Job name: Green Lane, Chesterton

Note No: C86354-JNP-XX-XX-RP-C-1007

Subject: Response to LLFA Comments

- 1.1 Oxfordshire County Council (OCC) have commented on the outline planning application at Green Lane, Chesterton, Bicester (reference: 23/00173/OUT).

Client: Wates Developments

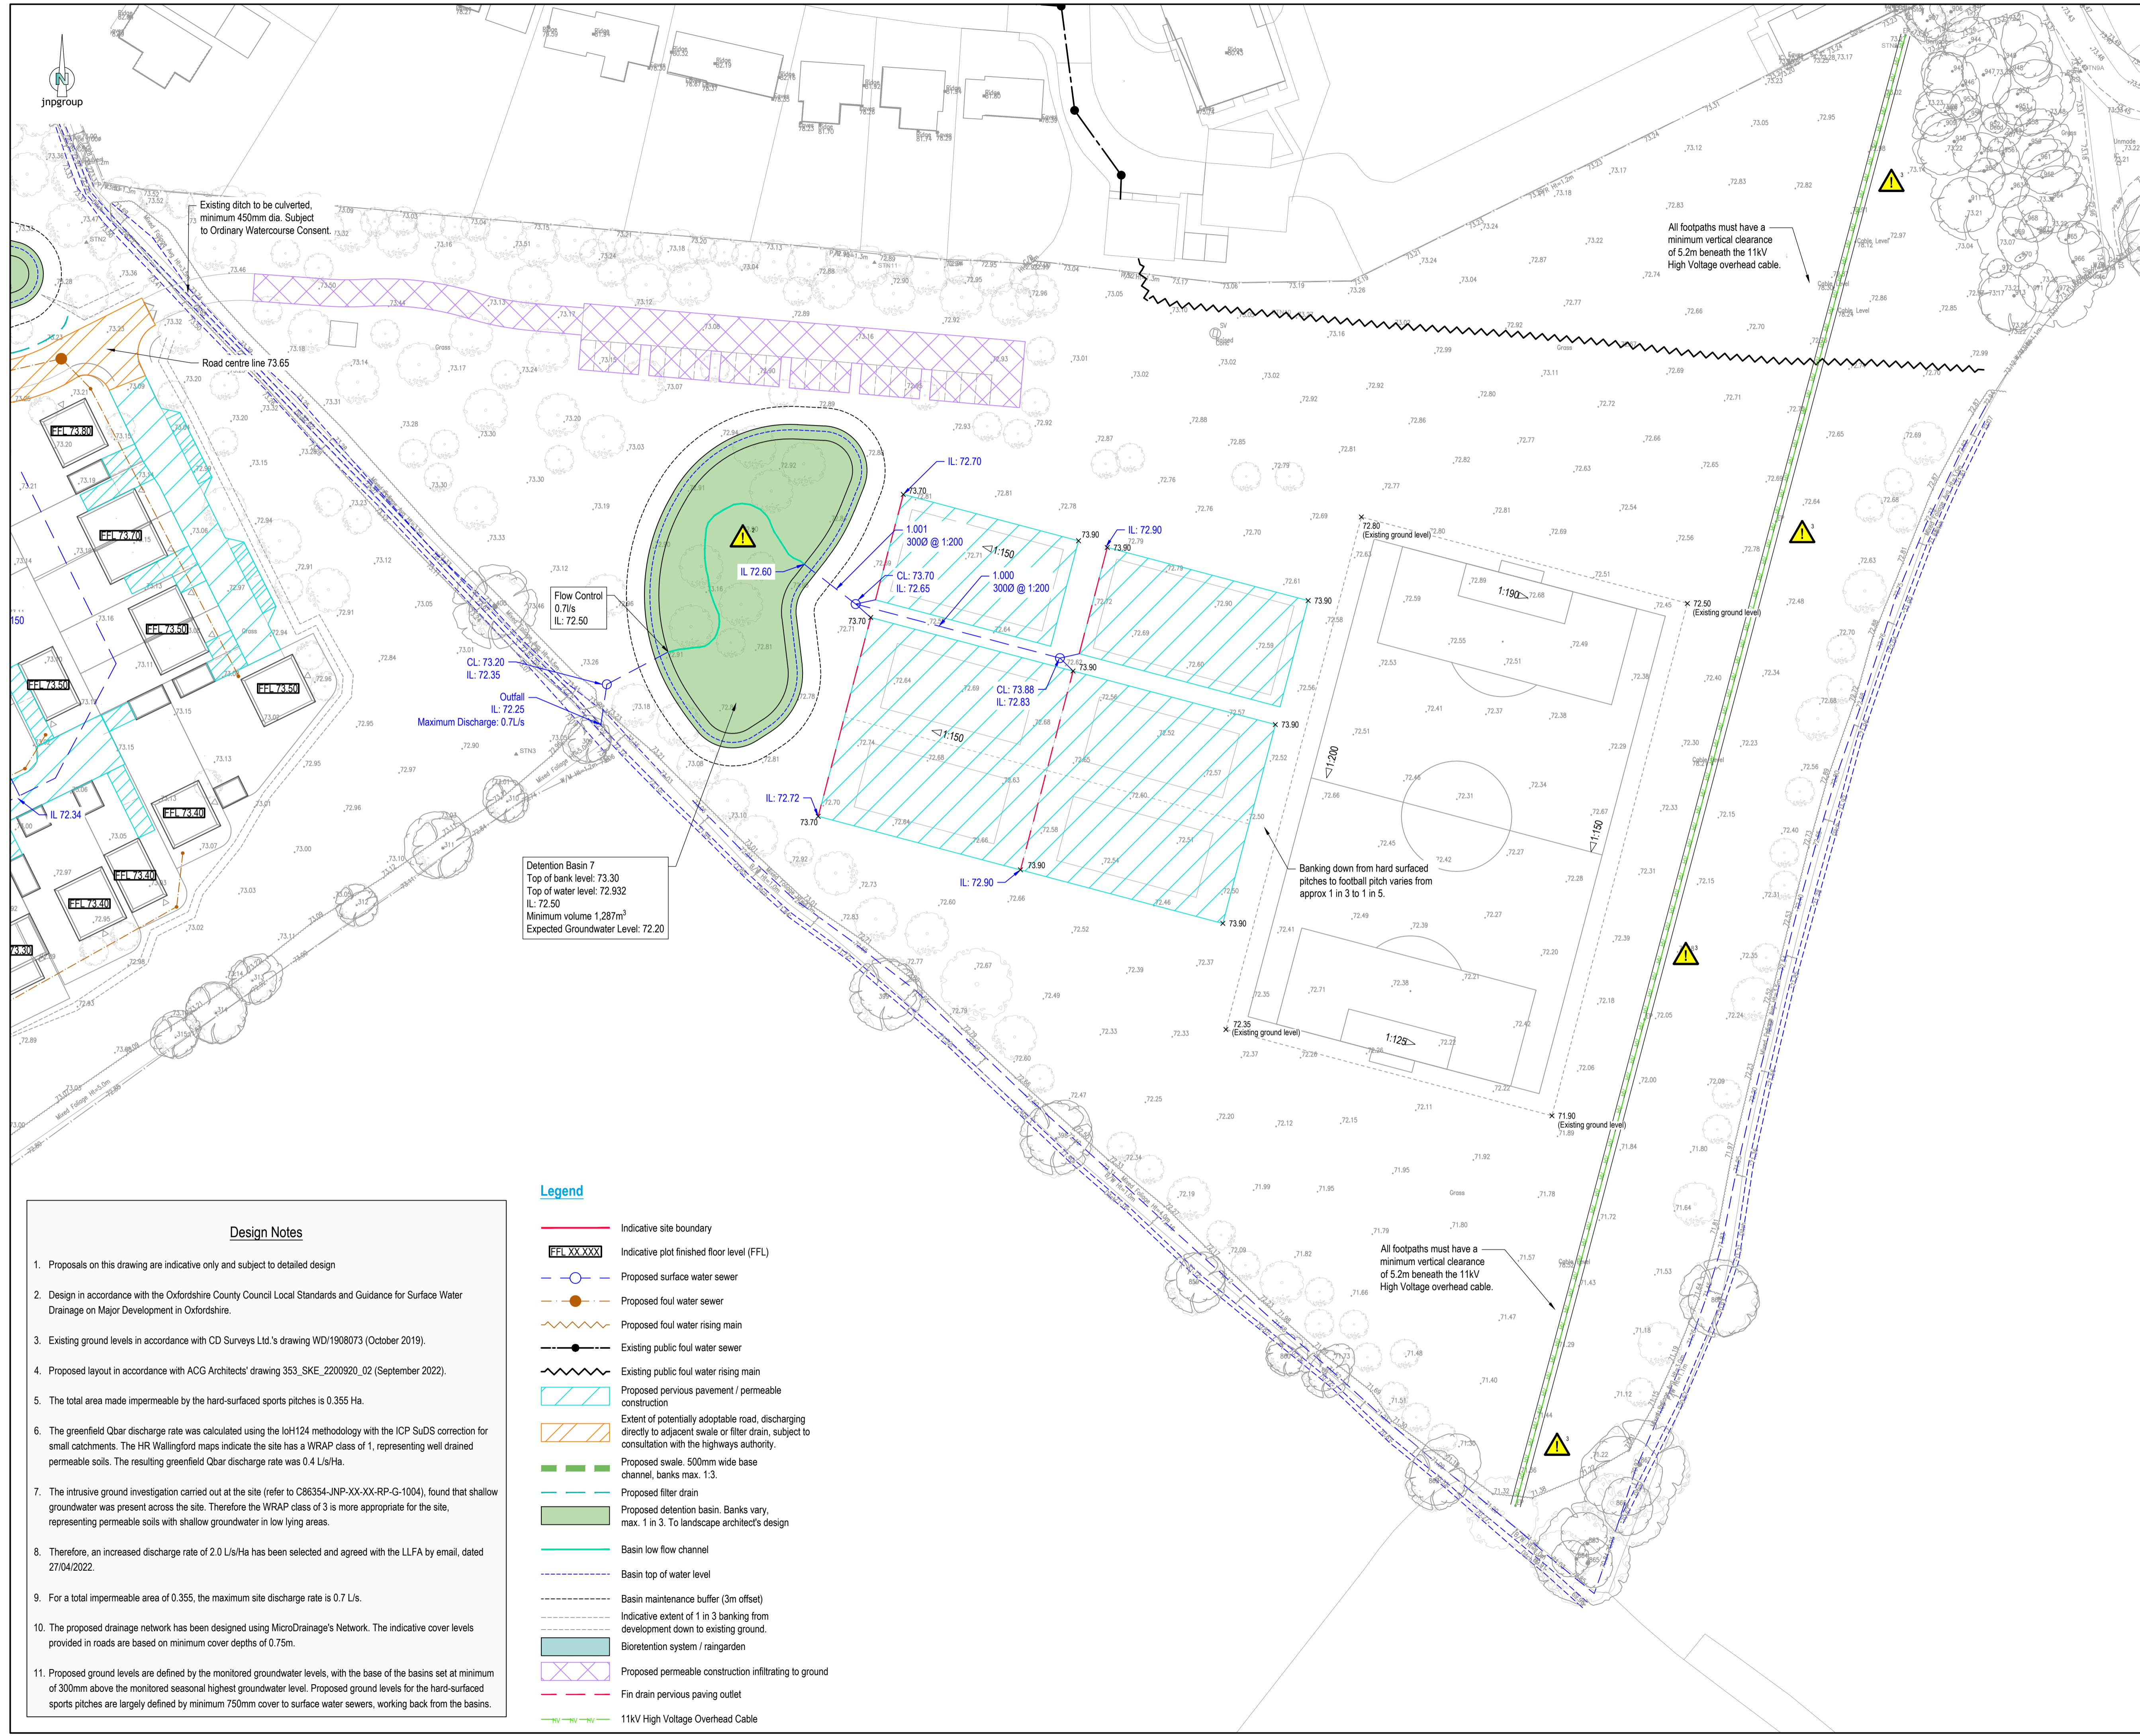
- 1.3 *'Clarify how the development will be phased. Provide phasing plan to illustrate this, each phase should be able to stand alone and have adequate flood mitigation measures in place.'*

- 1.4 A drainage phasing plan is provided within Appendix B. The phases shall be carried out in the following order to ensure that each phase has drainage infrastructure in place: Phase A, Phase B, Phase C.

- 1.5 Phase D is the eastern field and will be served by a separate drainage system to the rest of the development. Phase D can therefore be constructed at any point and independently of Phases A to C.

- 1.6 Within each phase the detention basins and flow controls shall be constructed at as early stage as possible within the works. During construction flows will be directed into the basins to ensure that surface water run-off is attenuated throughout.

Job: Land South of Green Lane, Chesterton

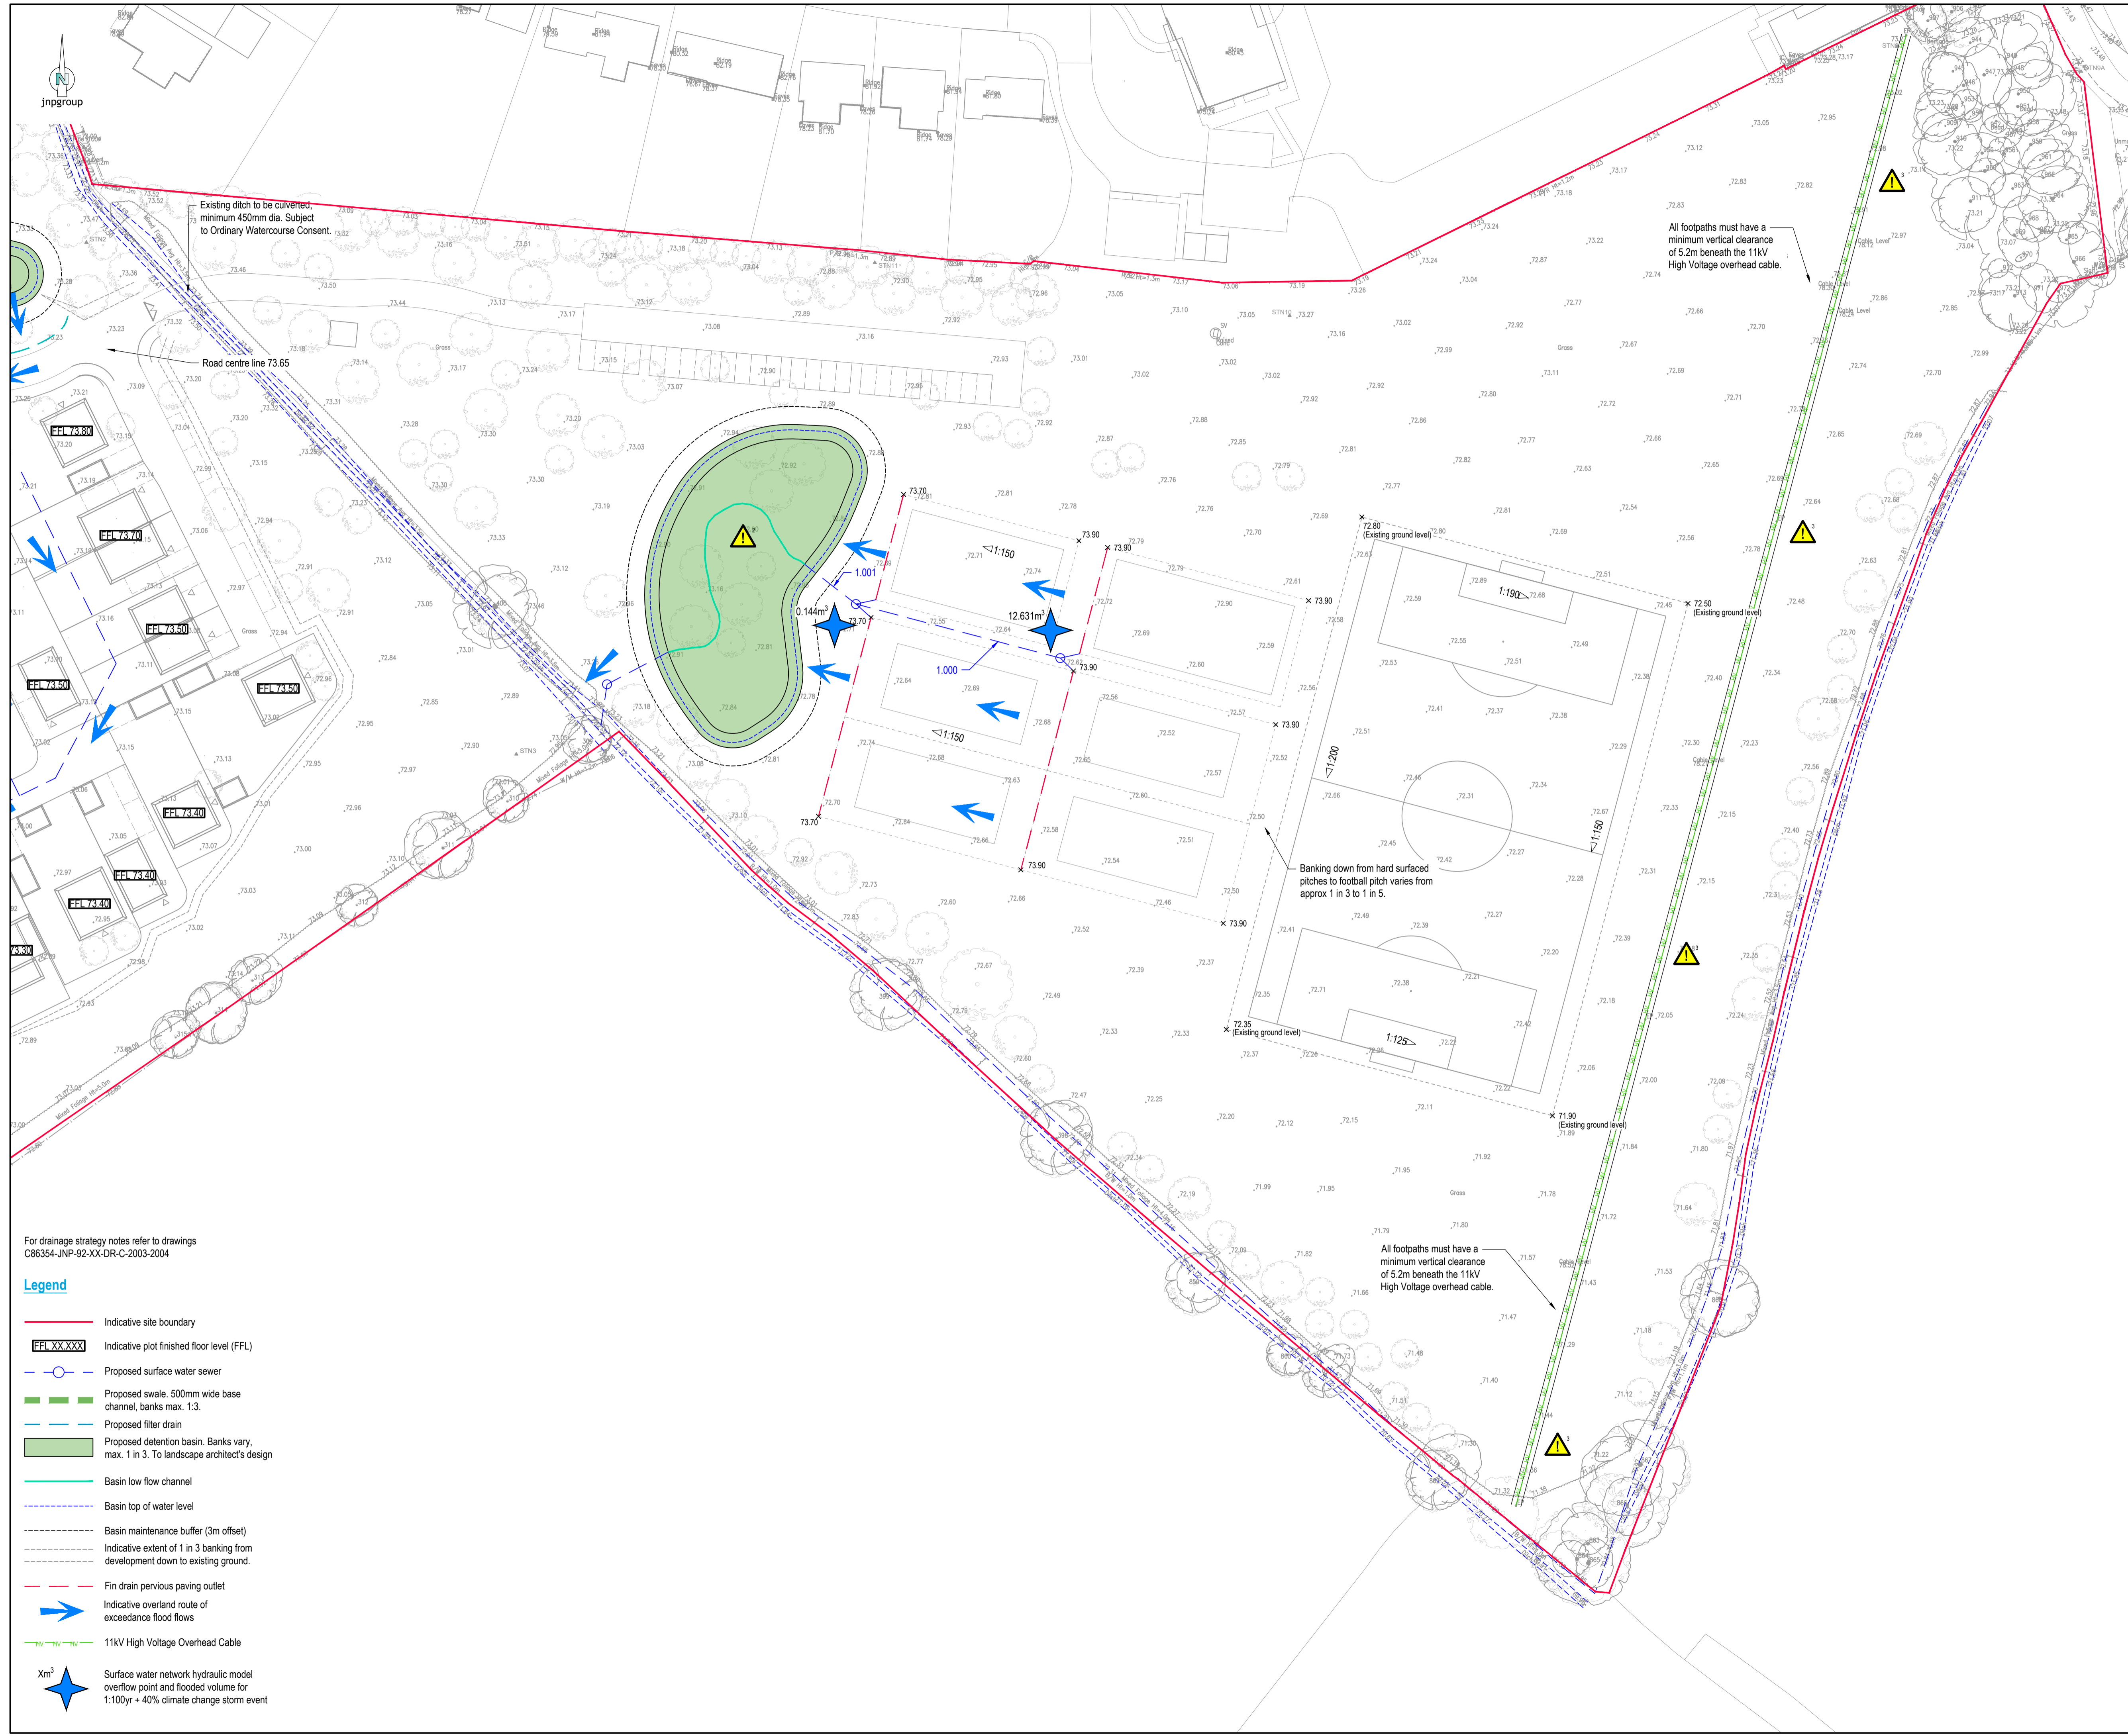
- 1.7 *'Provide details of the existing ditch, provide ownership details and consent to discharge surface water. Ensure the existing ditch has enough capacity to take the proposed loads from the development.'*

- 1.8 Details of the existing ditch network are provided in Appendix C. Two separate ditch systems exist as indicated on the plan. Ditch A runs along the southern boundary and Ditch B bisects the site splitting it into a western parcel and an eastern parcel.

- 1.9 Ditch A currently serve the western development parcel. Post-development the western parcel will continue to discharge to this ditch to mimic the existing situation. At the proposed outfall point, the northern bank of the ditch is within the site boundary (as shown on the Existing Ditch Network plan, Appendix C), the developer therefore has a riparian right to discharge natural flows to the ditch, subject to ordinary watercourse consent.

- 1.10 Ditch B currently serves the eastern development parcel. Post-development the eastern parcel will continue to discharge to this ditch to mimic the existing situation. At the proposed outfall point, the ditch is entirely within the site boundary (as shown on the Existing Ditch Network plan, Appendix C), the developer therefore has a right to discharge natural flows to the ditch, subject to ordinary watercourse consent.

- 1.13 Notwithstanding the above, the capacity of both ditches has been calculated at the two outfall points (as shown on the Existing Ditch Network plan, Appendix C). The western outfall rate is 6.2 l/s, the ditch capacity here is 794 l/s. The eastern outfall rate is 0.7 l/s, the ditch capacity here is 814 l/s. In both cases the proposed discharge rate is a small fraction of the ditch capacity. Calculations for the capacity of the ditches are included in Appendix E.
